STATE OF NORTH CAROLINA
DEPARTMENT OF TRANSPORTATION

Addendum No. 1

RE: Contract ID: C201626
WBS# 38132
Pitt County
NC-33 From West City Limits of
Grimesland to 5 Lane Section in Sampson.

PROJECT REFERENCE NO.		SHEET NO.	
38132		1	
ROADWAY DESIGN ENGINEER		PAVEMENT DESIGN ENGINEER

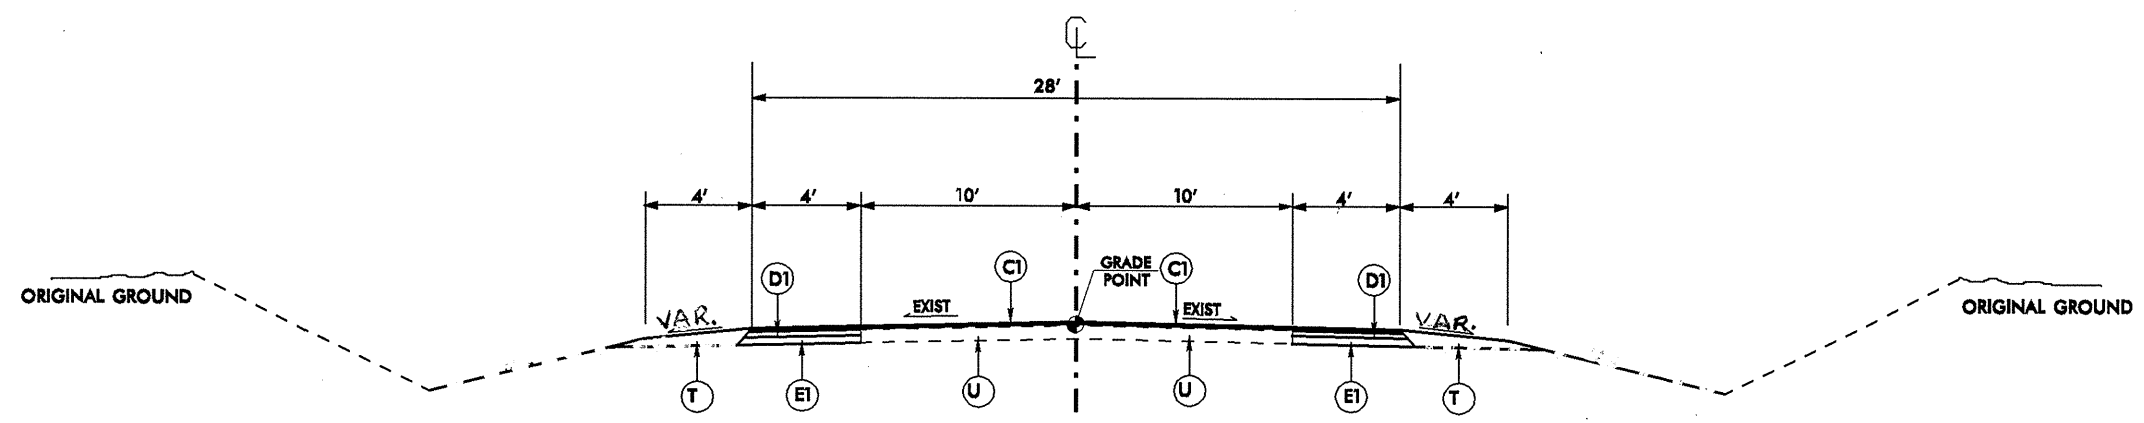
Sheet Nos. 1 and 2 were revised to reflect the change from "Shoulder Construction" to "Shoulder Reconstruction" and to add a note concerning moving of ditches. Please void Sheet Nos. 1 and 2 in your sketch maps and replace with the revised Sheet Nos. 1 and 2.
